**Consultation Response from KC,
Highways Development Management**

2024/92528 The Eden Foundation, 31, Acre Street, Lindley, Huddersfield, HD3 3DZ

**Demolition of existing rear extension, erection of rear extension to include a staircase,
reconfiguration of existing roof including the removal of chimneys and formation of basement
entrance**

Date Responded: 13/11/2024.

DRAWING TITLE
GENERAL ARRANGEMENT - PROPOSED

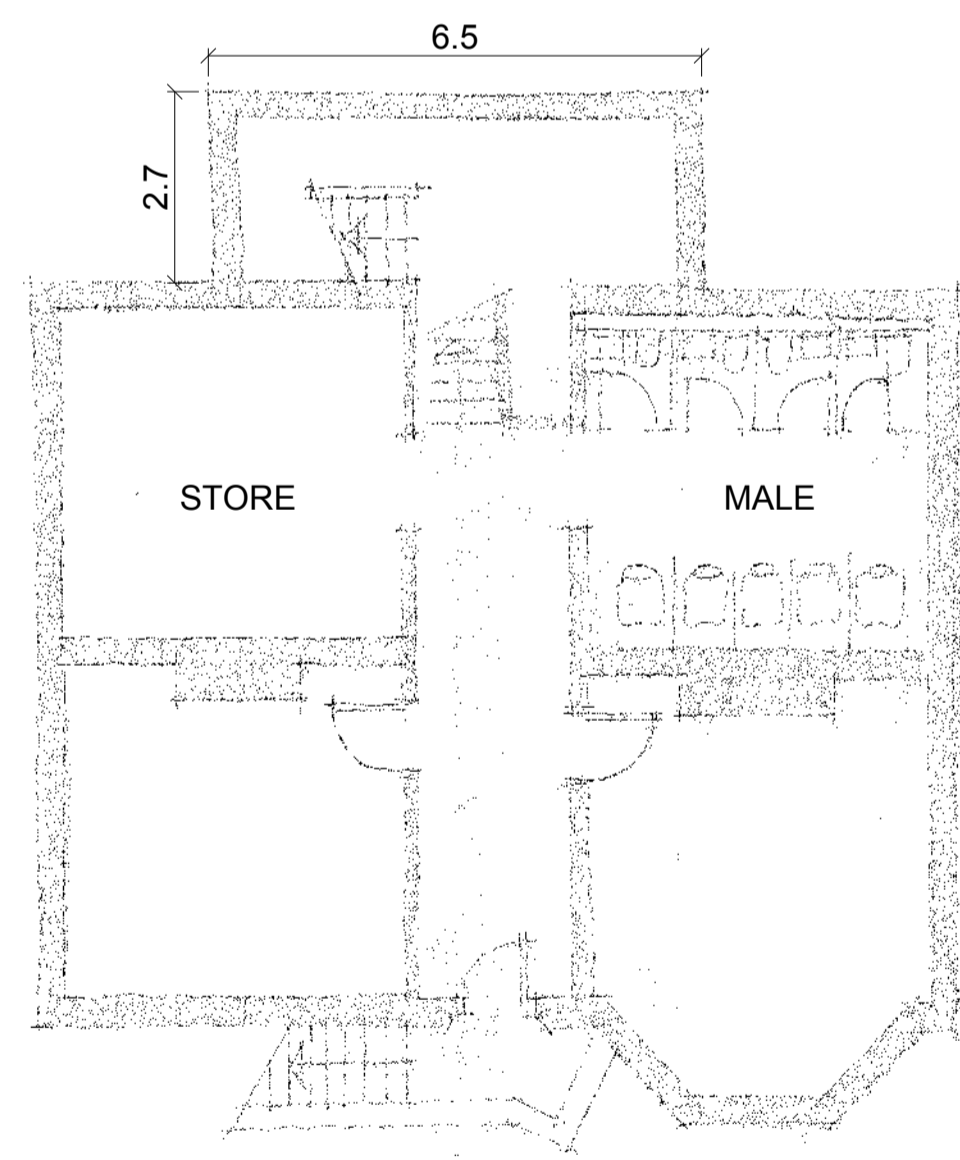
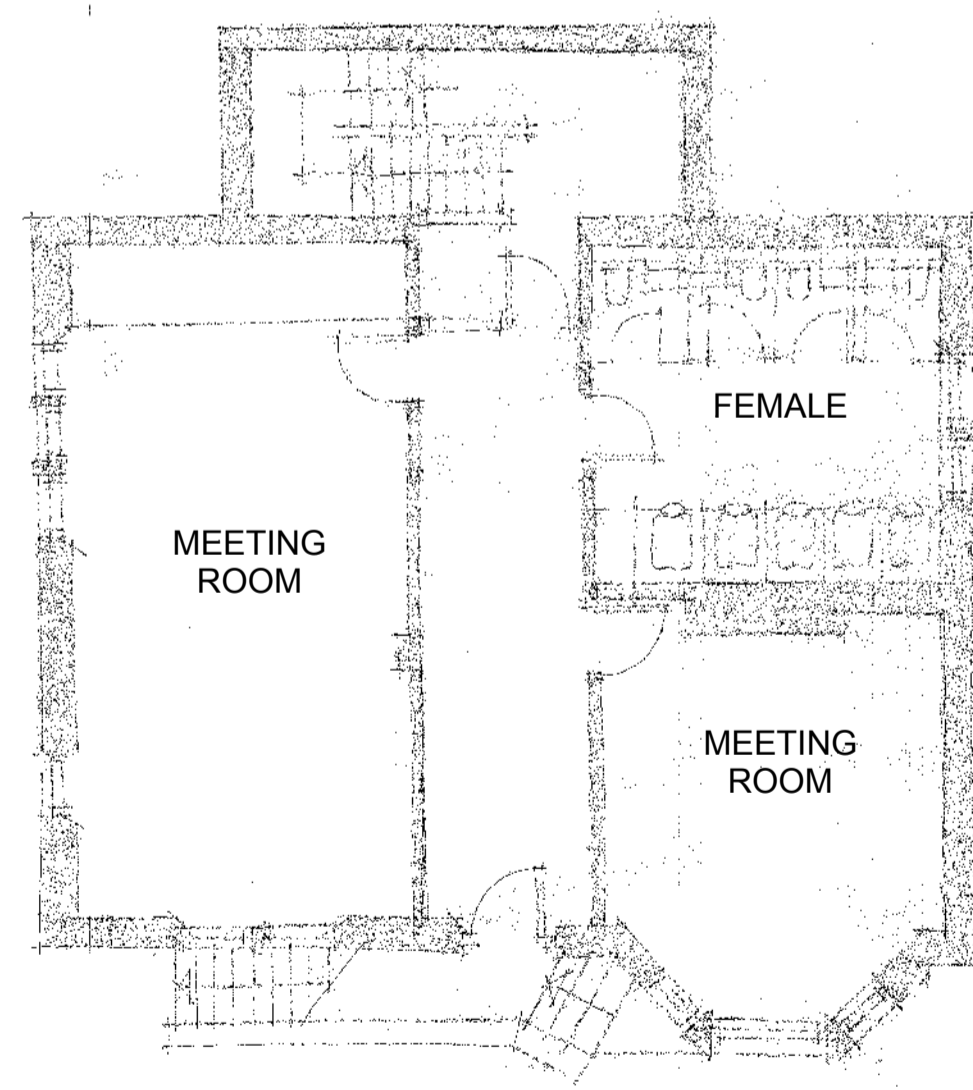
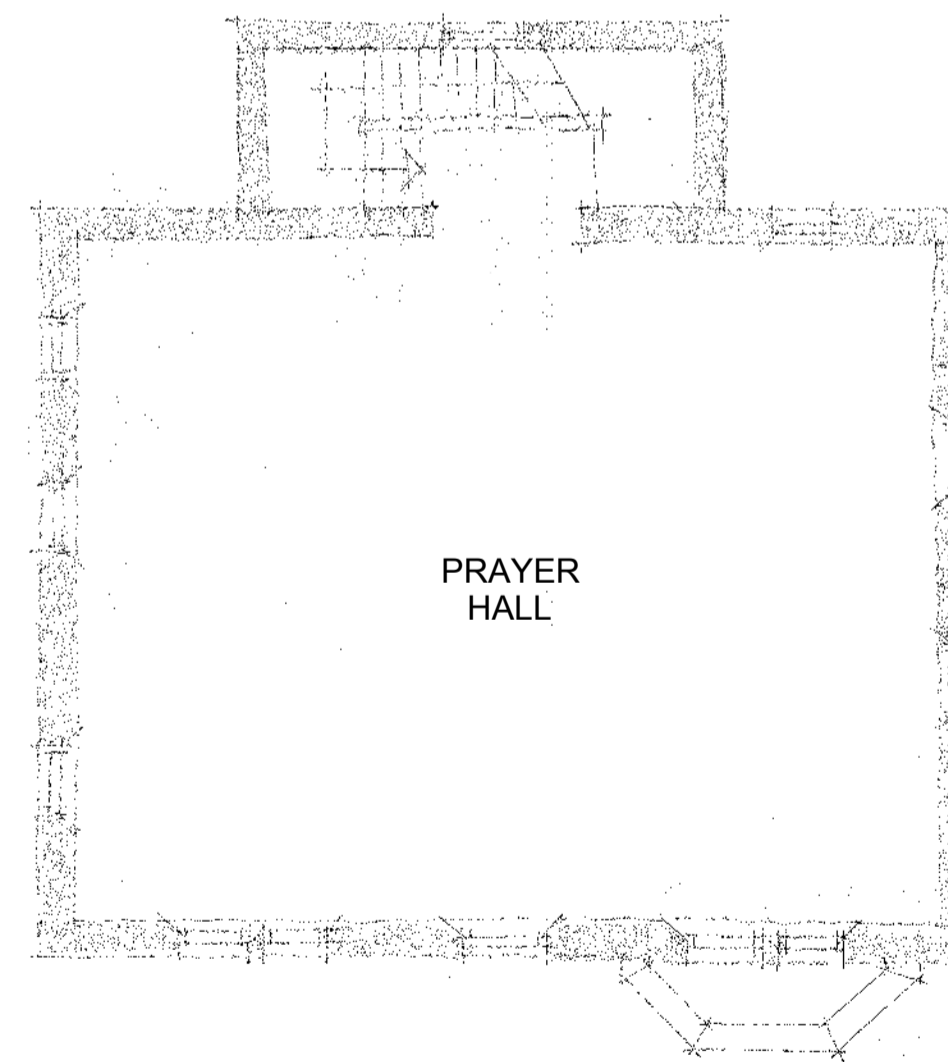
This application, although similar in overall size to the previously approved application appears to increase the size of the Prayer room and therefore the capacity of the Centre accordingly.

In principle, whilst it would be difficult to raise an highways objection to this proposal, clarification on the capacity of the centre would need to be determined as it seems that this application will increase the number of visitors/attendees to the the centre above that of the previously approved application.
